Planning Application No: 3/2025/0631

Proposal: Proposed two-storey side extension and the demolition of single-storey garage.

Location: 21 Woodside Road Simonstone BB12 7JG

**7239 - P02A**

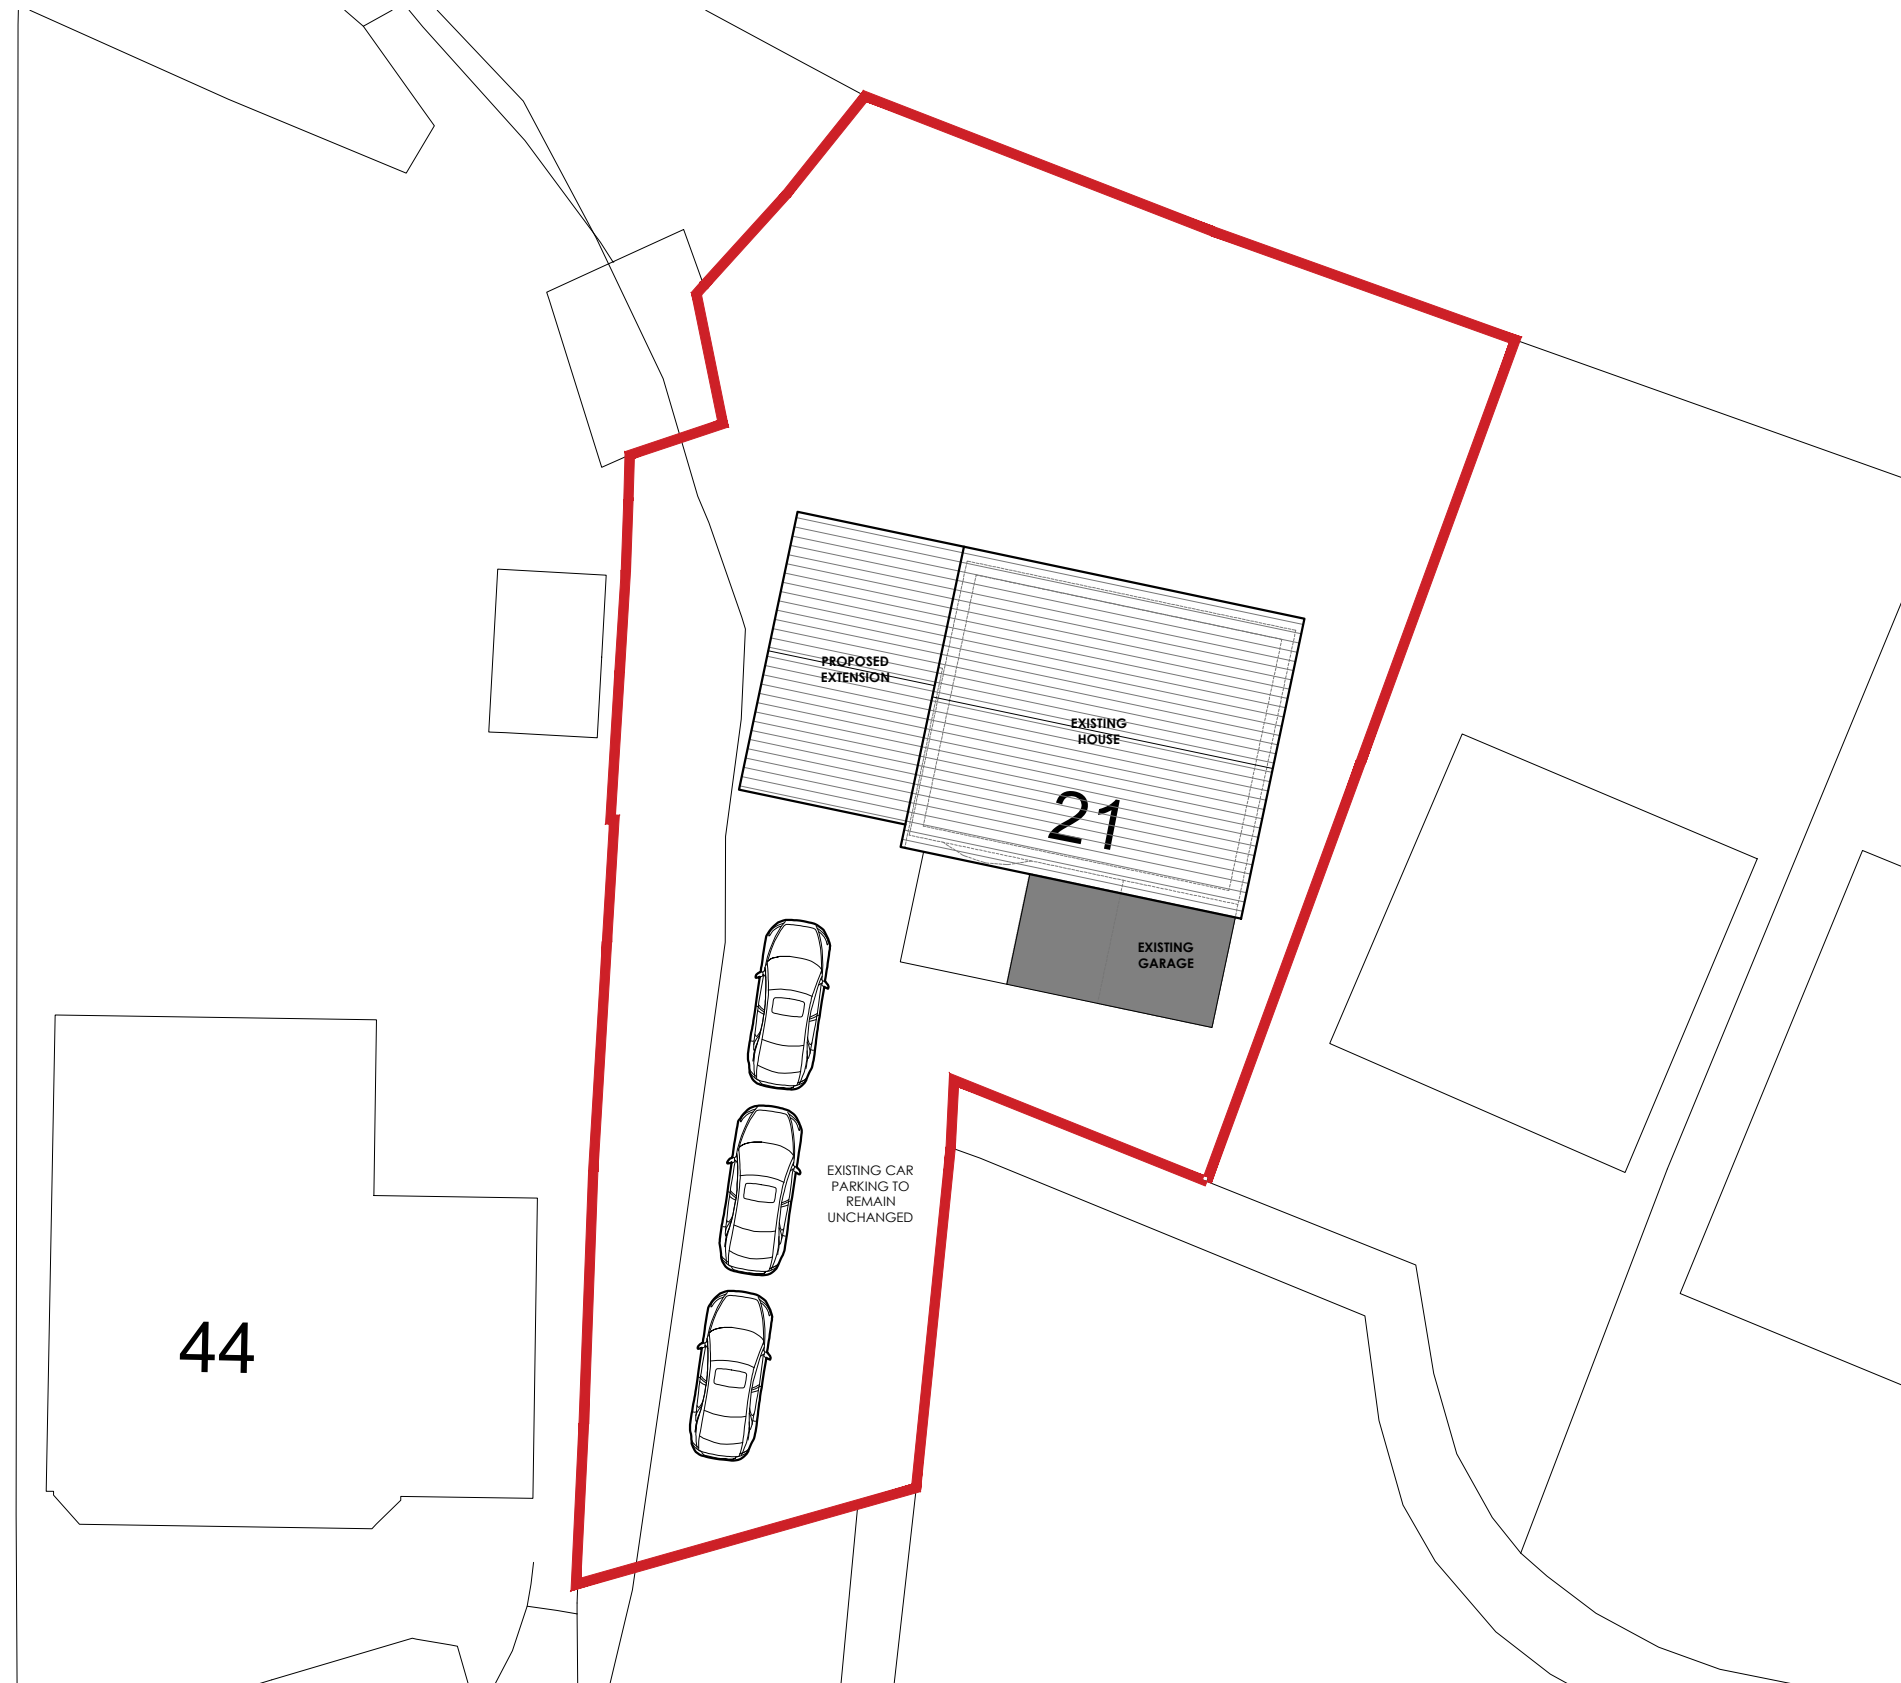
Further to the amended consultation, the existing car parking is to remain unchanged; ref. Proposed site plan and car parking plan 7239-P02A submitted, Rev A car parking added 3.10.25, therefore, there is no objection to the proposal, as parking standards requirements are being met for the proposal.
